Recommendation Report for Planning Permission for Works or Extension to a Dwelling

REF NO: LU/364/18/HH

LOCATION: 21 Northway Road
Littlehampton
BN17 7JX

PROPOSAL: First floor pitch roof rear extension

Title
Plans as Proposed

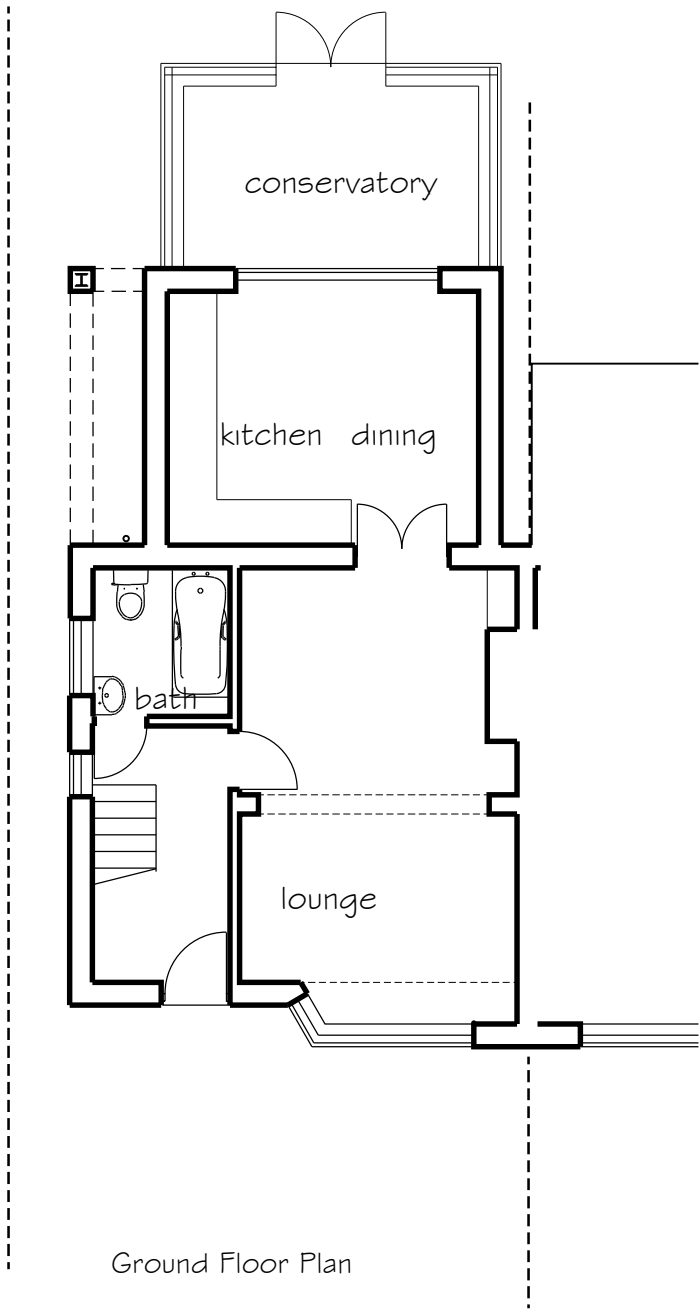
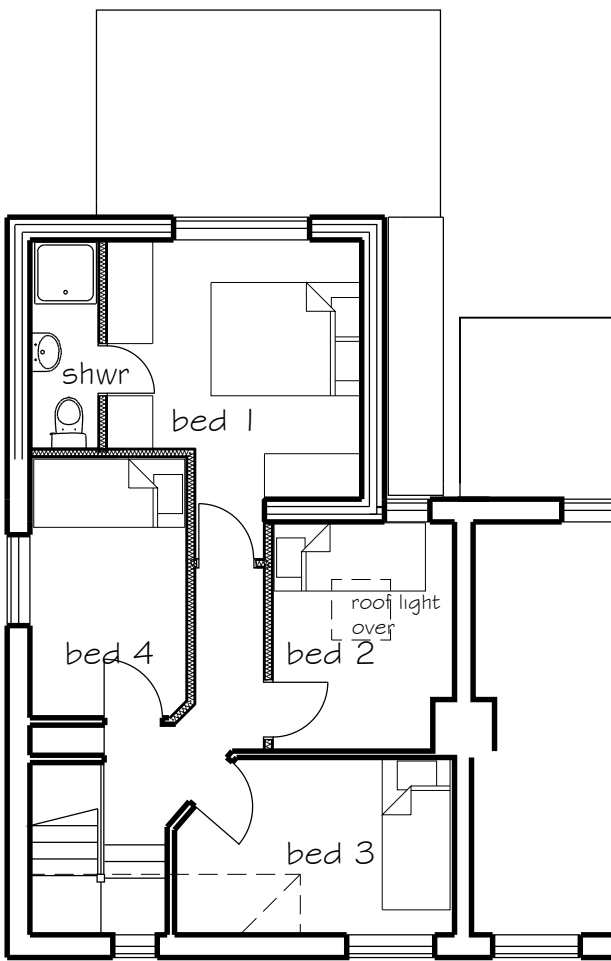
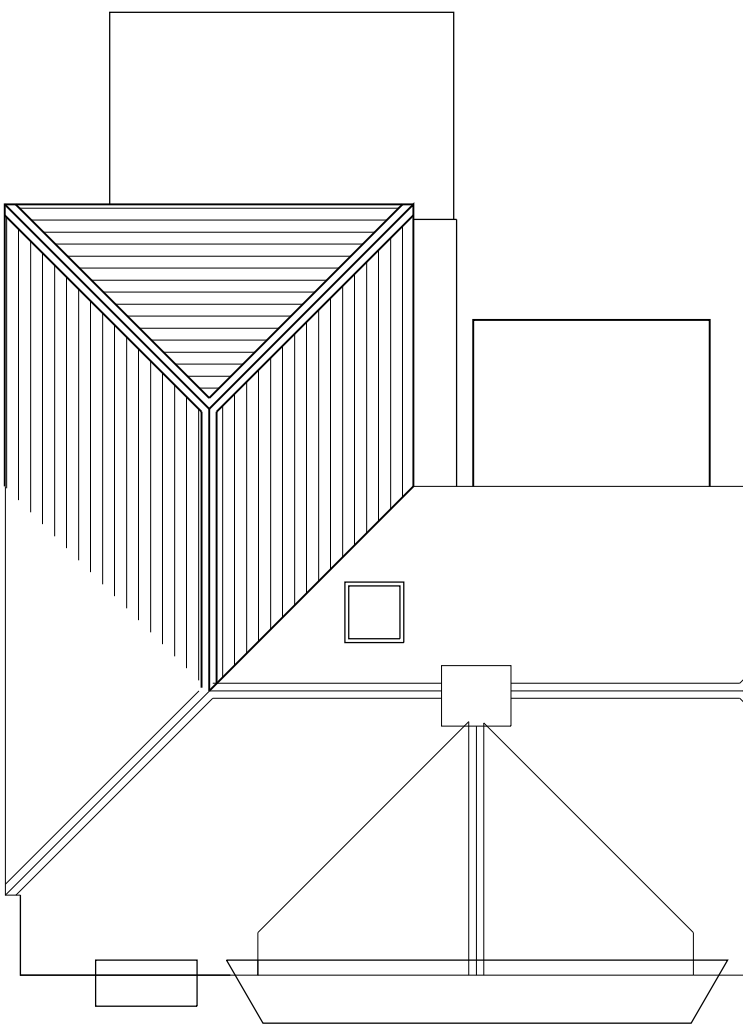
The proposed development is not considered to have a significantly detrimental impact on residential amenity. The proposed development is 1m from the boundary with the adjacent occupier to the North, so

it is not considered to have a significantly detrimental impact on overbearing at neighbouring dwellings. To the North, #22 Northway Road has a single storey rear extension, of which the proposed development extends no further East beyond this line. With regard to overshadowing, the proposal is not considered to cause any significant loss of light given lighting available from the rear of rear part of the neighbouring property. Additionally, whilst it is noted that the extension features Juliet balconies, it is not considered that these provide any views that are not available from the host dwelling as current. Resultantly, the proposed development is considered to be in accordance with D DM1(3) and D DM4(c) of the Arun Local Plan.

Title
Elevations as Proposed

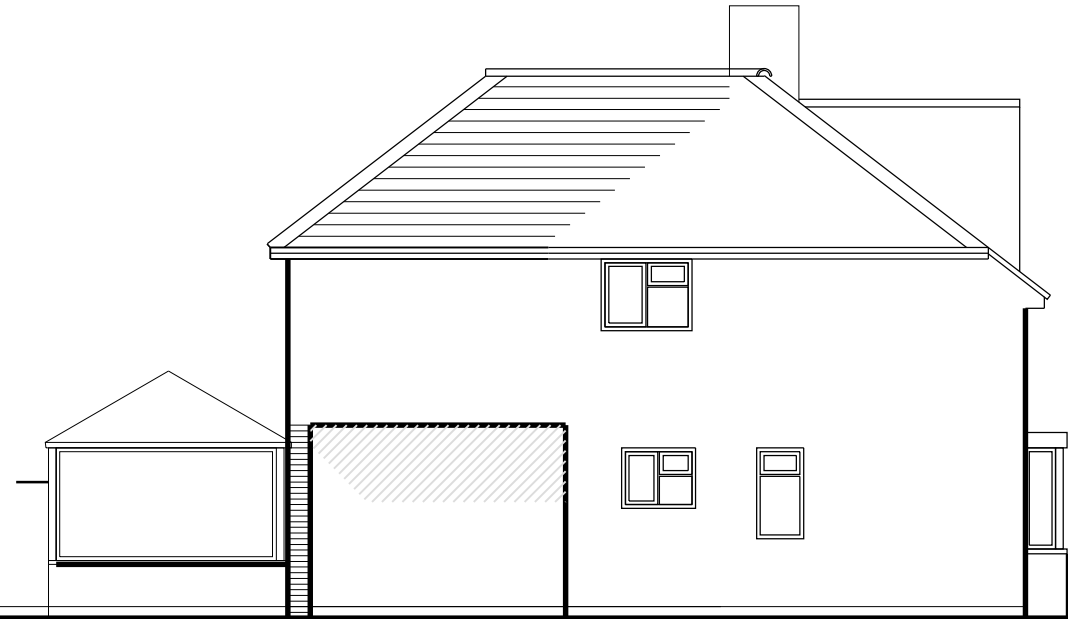
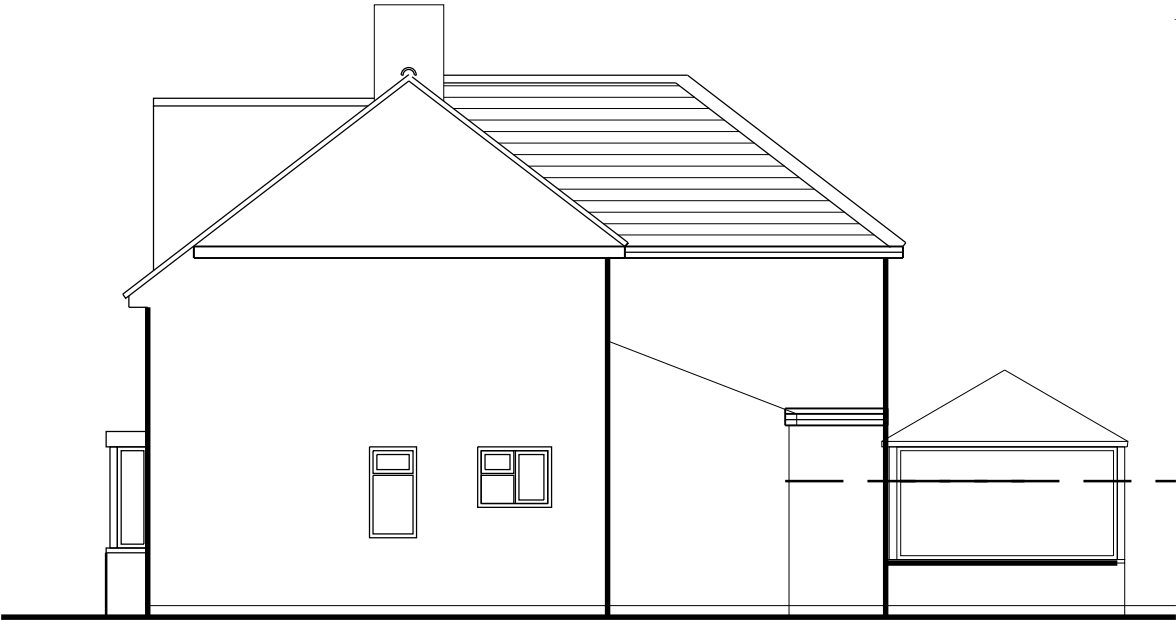
The proposed extension is considered to significantly alter the appearance of the host dwelling within the residential plot, as a result of its significant scale. Whilst it is well integrated with the host dwelling, it is not considered to be a subservient addition, result of said scale. Therefore, it is considered that the proposed development is in conflict with D DM4(b) of the Arun Local Plan. However, as a result of the design of the proposal, this alteration is not considered to be harmful to the existing character of the host dwelling, nor represent an overdevelopment of the site. The proposed extension matches the design of the host dwellings roof, with regard to ridge height and roof slope angle. The proposed materials match the existing property, which is considered to allow the extension to harmonise with the dwelling in terms of its appearance. The proposal is considered to be sympathetic to the character of the host dwelling, and a well integrated addition to the rear elevation. Therefore, whilst it is noted that the proposal is in conflict with D DM4(b), it is considered to be in accordance with D DM1(2) and D DM4(a) of the Arun Local Plan.

By virtue of the siting of the development, there are few available views of the proposed development from the street scene. Therefore, the proposed development is not considered to have a significant impact upon the character of the area, as it is not visible from the public realm, and can have no impact upon the spatial pattern of the locality, when viewed from the street scene. The proposed development is considered to be in accordance with D DM1 of the Arun Local Plan.
